**Consultation Response from Mike Hibbert,
 KC Waste Strategy(Refuse & Recycling)**

2023/93539 Land adj, Ledgard Bridge Mill, Back Station Road, Mirfield, WF14 8NZ

Outline application, including the considerations of access appearance, layout, and scale, for the erection of a six-storey building to host 76 residential apartments (C3 use) and ancillary works comprising demolition of vacant building, formation of new access, parking areas, open space and landscaping; erection of cycle and bin refuse storage structures

Responding Ref: WPN 23-065

Timber Clad Refuse/ Recycling Store Elevations 1: 100

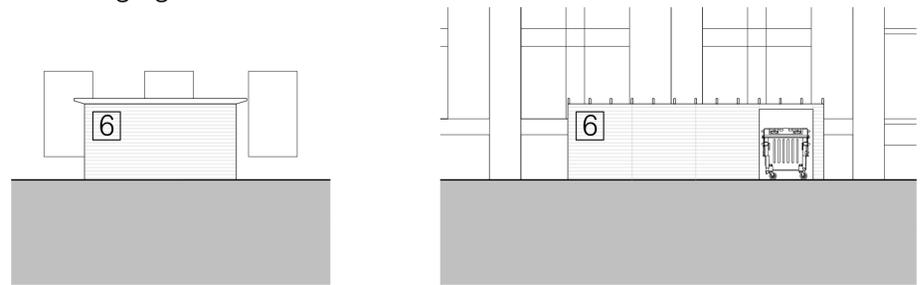
The new stores [6] shown on the drawings are within 30m of the building, with screening and better access for an RCV.

- The floorplans are large enough to accommodate the nine wheeliebins shown in each store.
- It is not clear from the plan how bins will be removed from the Northern store onto the car park. It may be more appropriate to alter the access to the bin store and hatch the nearest parking space or maybe reorientate the store into the hatched parking areas and create a new access point.
- **If not already in the design, drop kerbs should be installed to enable transfer of wheeliebins from the store/ path to the carpark for loading onto an RCV.**

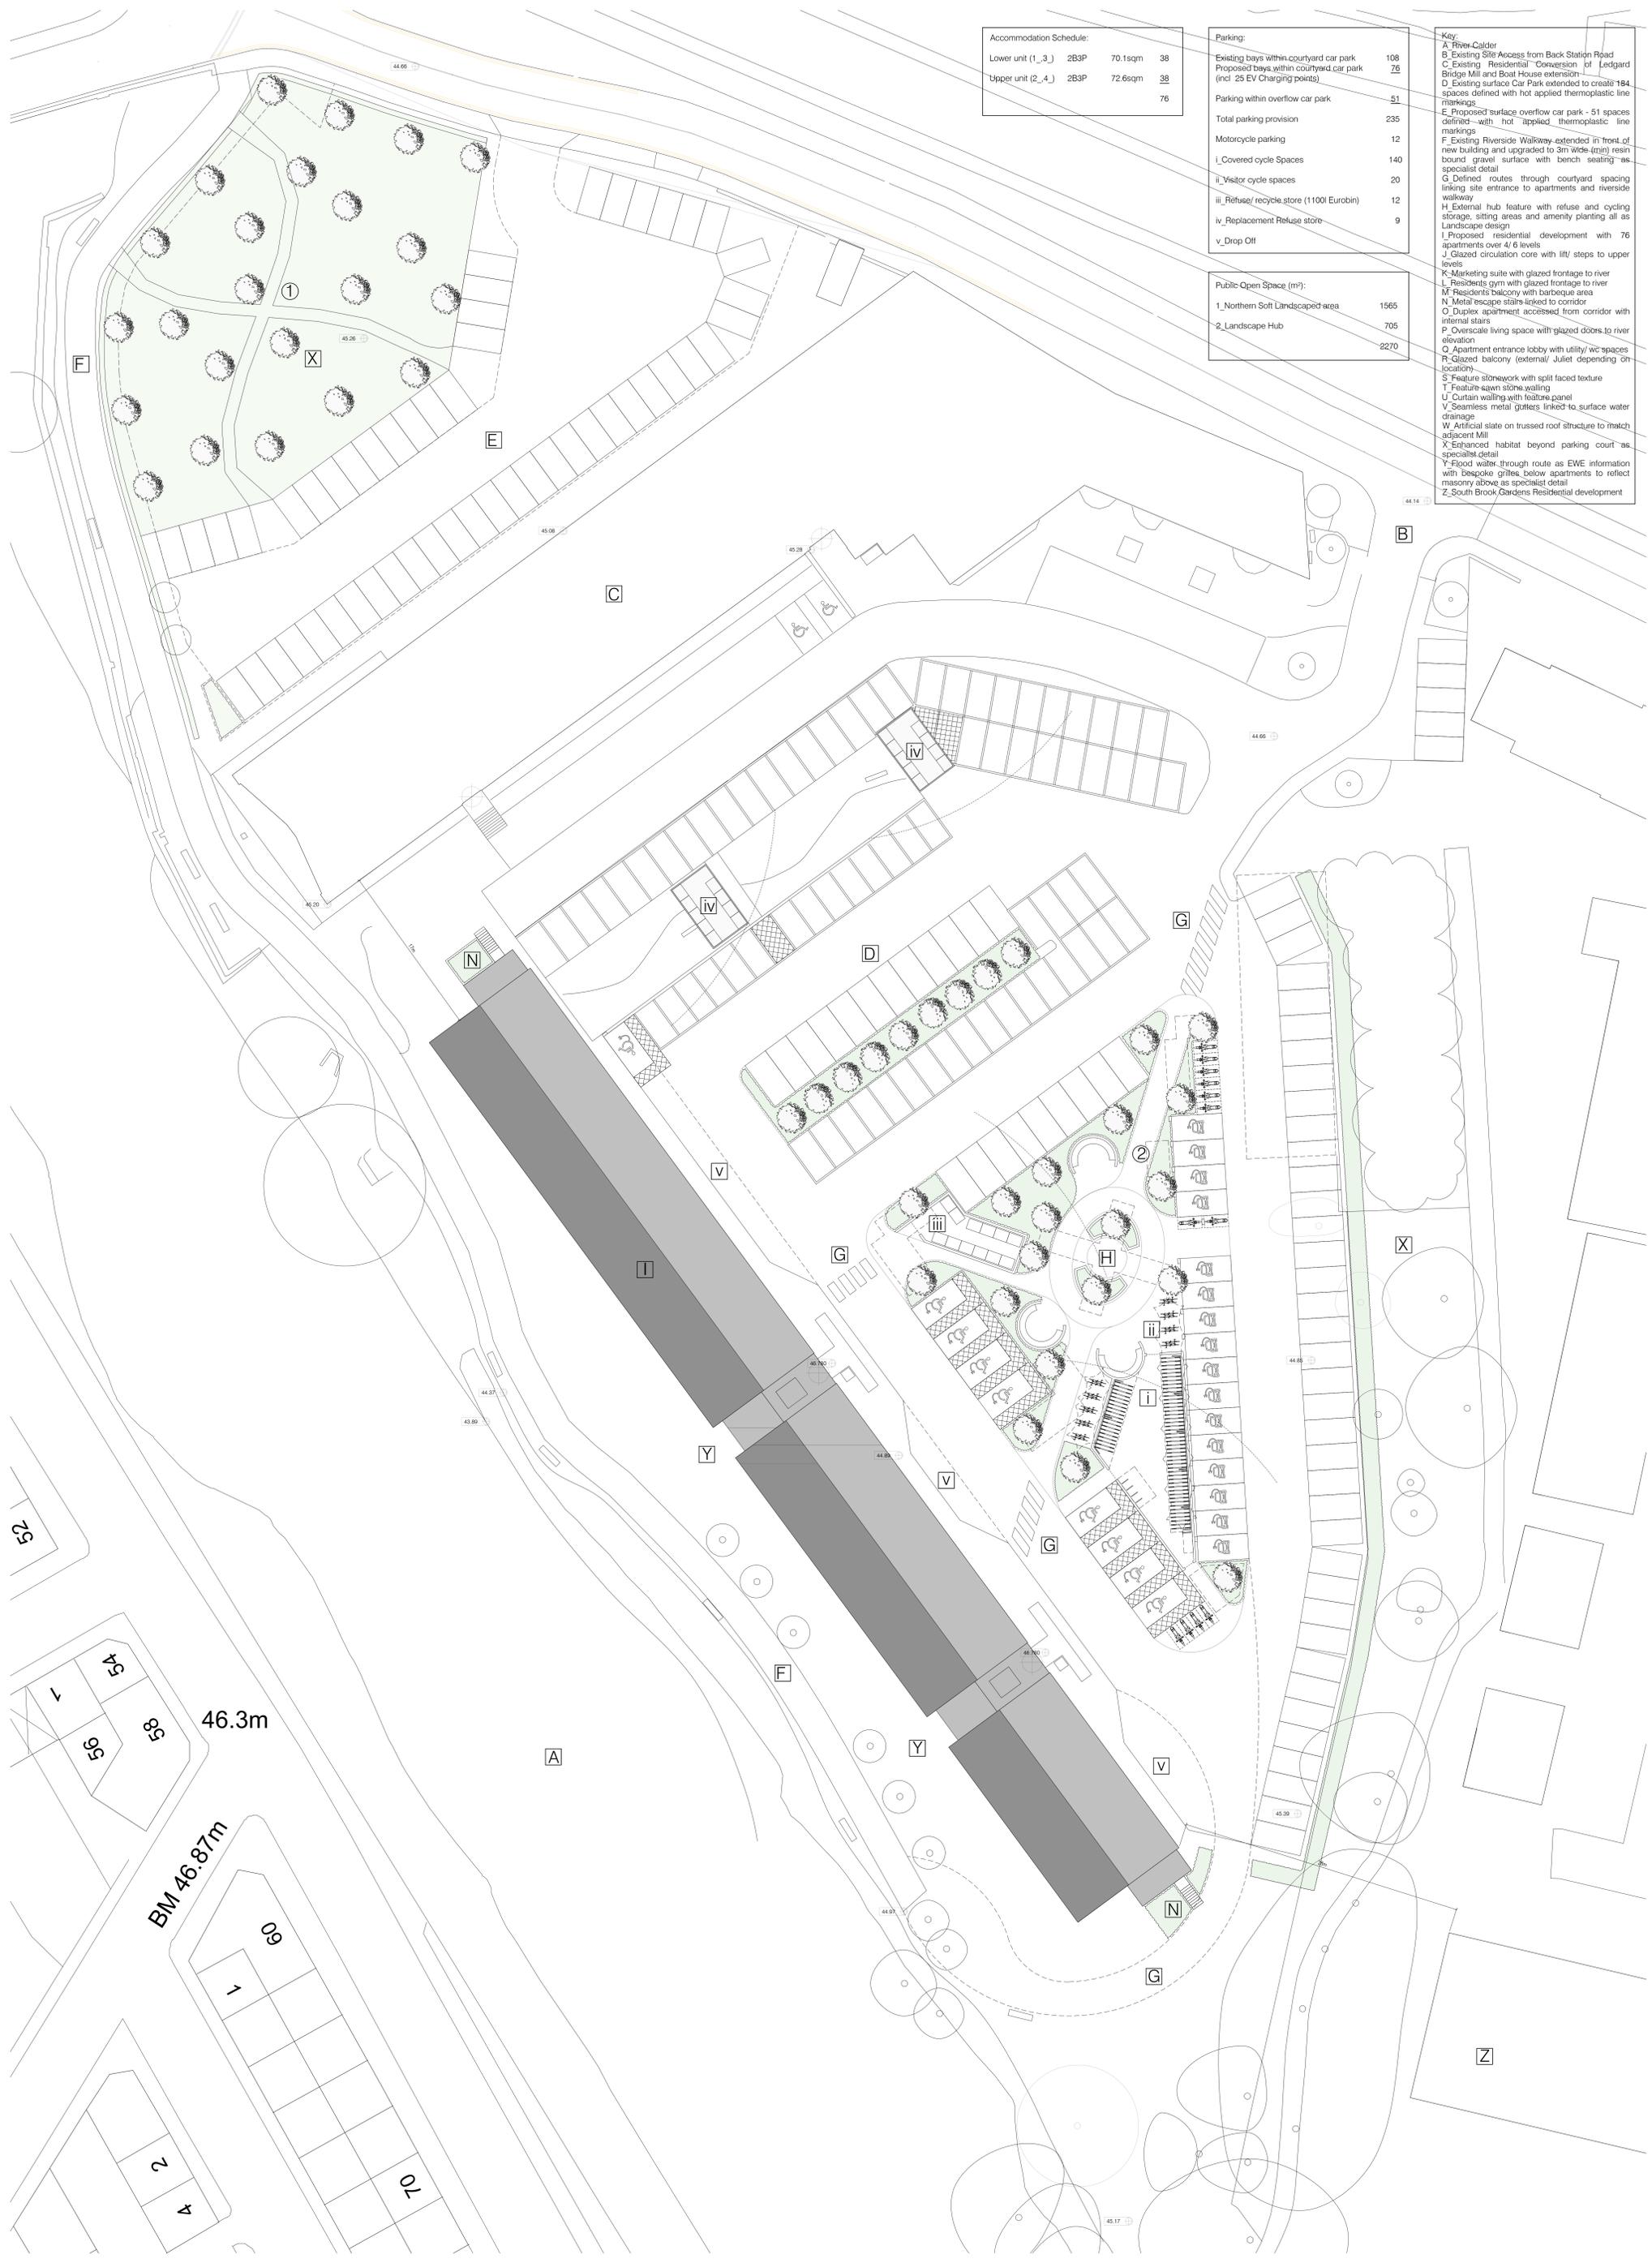
- The location of the new and relocated bin stores are shown on Dwg Title (17001)2_Site Plan Rev F Dated December 2023 and Dwg Title (17001)13_Landscape Hub Rev A Dated Nov 23 Car Park Hub 1_ Refuse/recycling store. The landscape drawing is annotated with the detail of Brickwork enclosure with returns. The stores are <30m from building entrances (indicated with dotted

- Guidance indicates the floor space for a 1100ltrs wheelibins is 1575mmx1190mm with space to manoeuvre the bins within the store. The bin stores are screened and are approximately 11.5m and 5.8m long respectively. Using these dimensions, the wheeliebins, eight and four respectively, should just fit in the stores. Bin store surfaces should be durable and waterproof enough to withstand heavy duty cleaning such as power washing.
